Consultation Response from: KC Environmental Health (Pollution & Noise Control)
2025/93210 Land Adj, 178, Deighton Road, Deighton, Huddersfield, HD2 1JJ
Erection of one detached dwelling
Date Responded:
Thursday, 22 January 2026

Responding Officer:
Hannah Kent

Responding Ref:
WK/202601458

DRAWING TITLE
Location Plan and Existing Site Plan

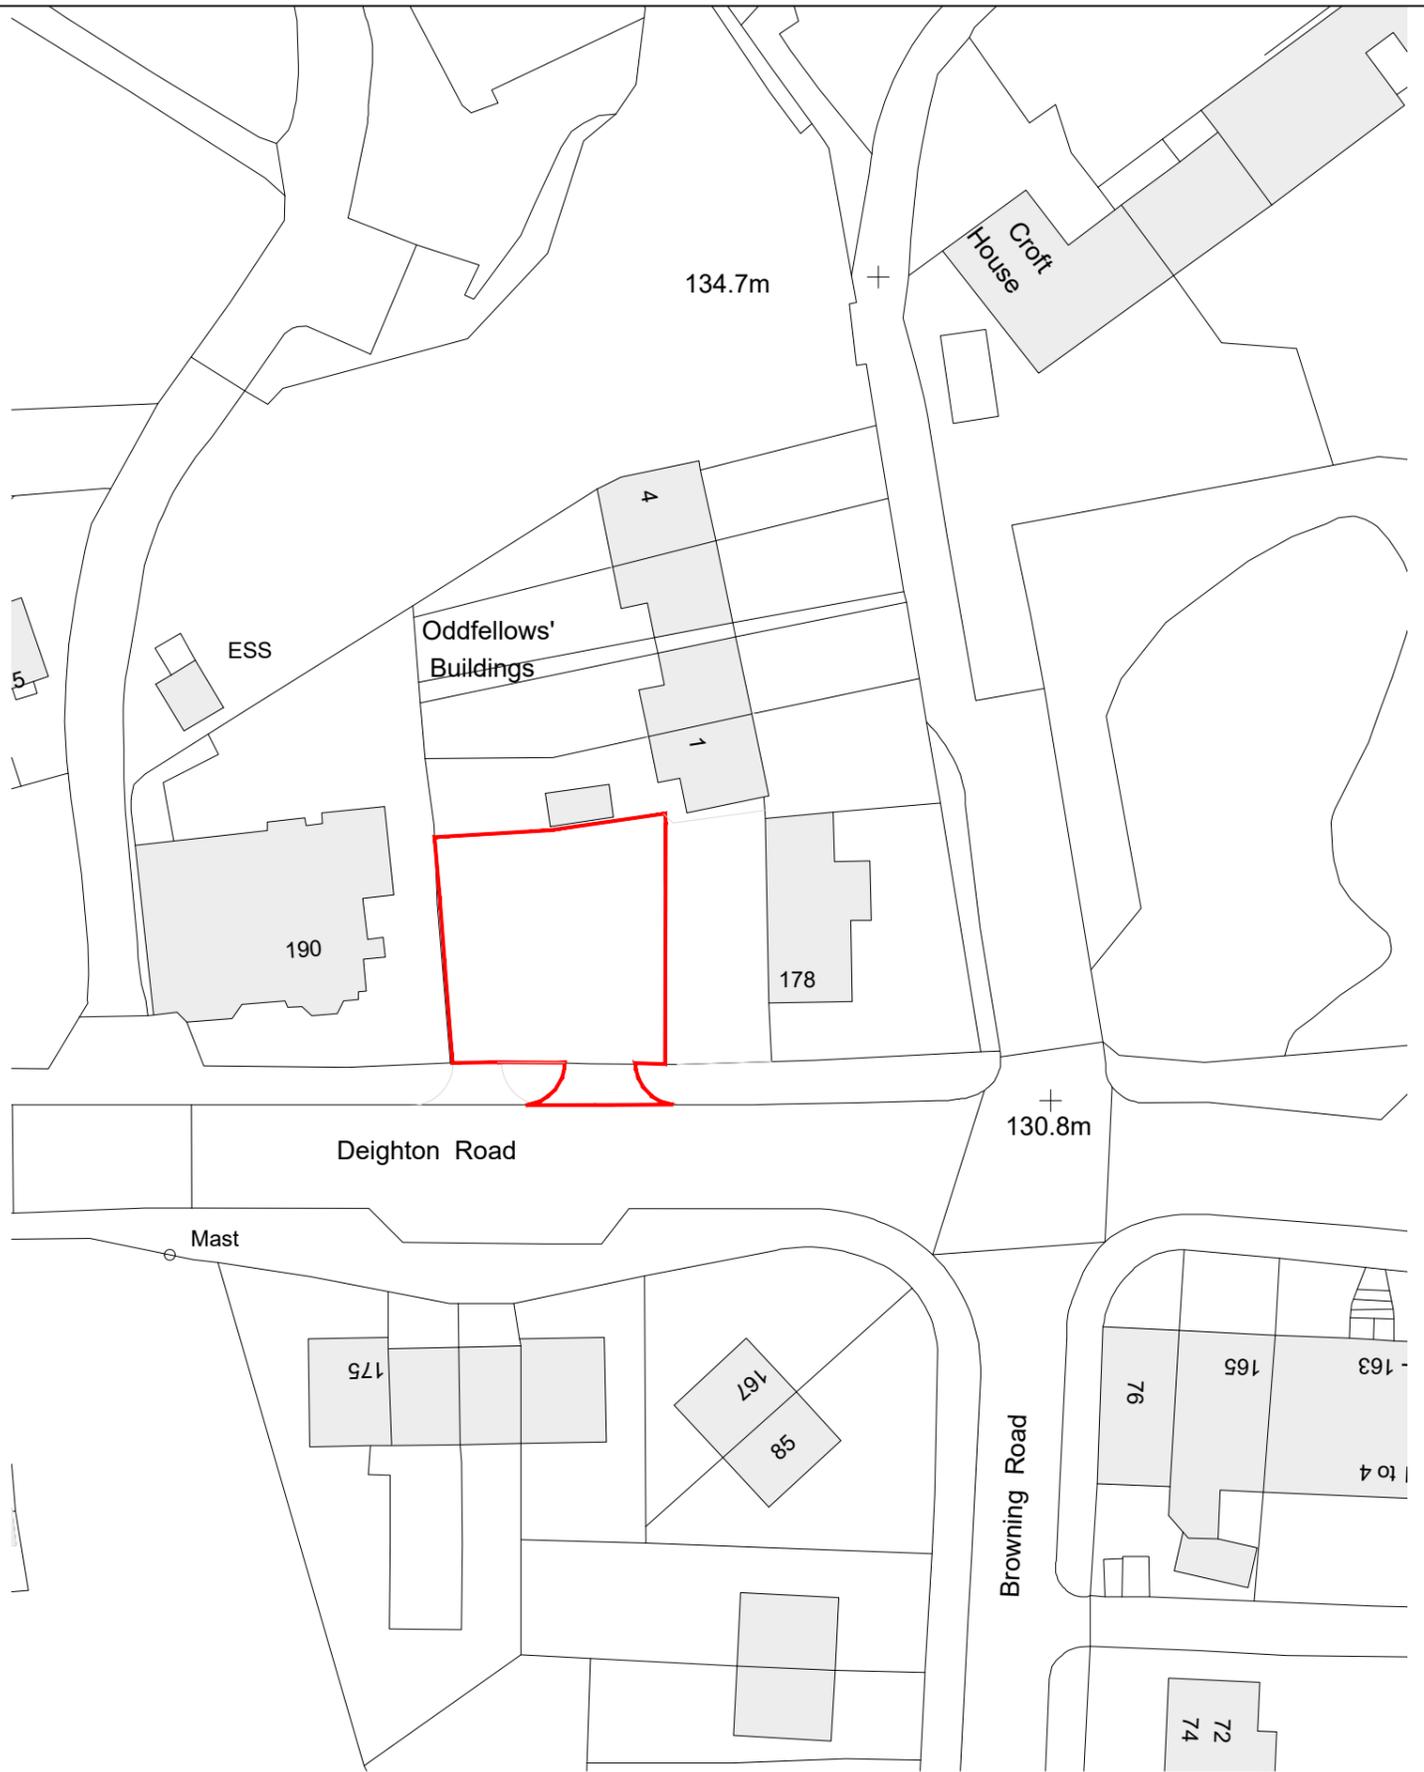
- Further details are required to justify / link back to the sites history, potential sources of contaminants and where sampling was required to confirm whether contaminants associated with past site use are present, or absent.
- The location of sampling should also be linked with the proposed use – it appears that the submitted contaminated land assessments were undertaken for a previous planning application as the submitted plans do not include the workshop within the site

layout. If the site layout has changed, all the contaminated land assessments will require updating with the most recent changes to the site layout.

The additional supporting information provided within the Phase II assessment identifies that the application for erection of one detached dwelling also includes a large workshop. It is not entirely clear if this still applies (as the workshop is not included in the submitted plans).

Further information is required if the workshop is still included to enable Environmental Health to provide an informed and detailed response.
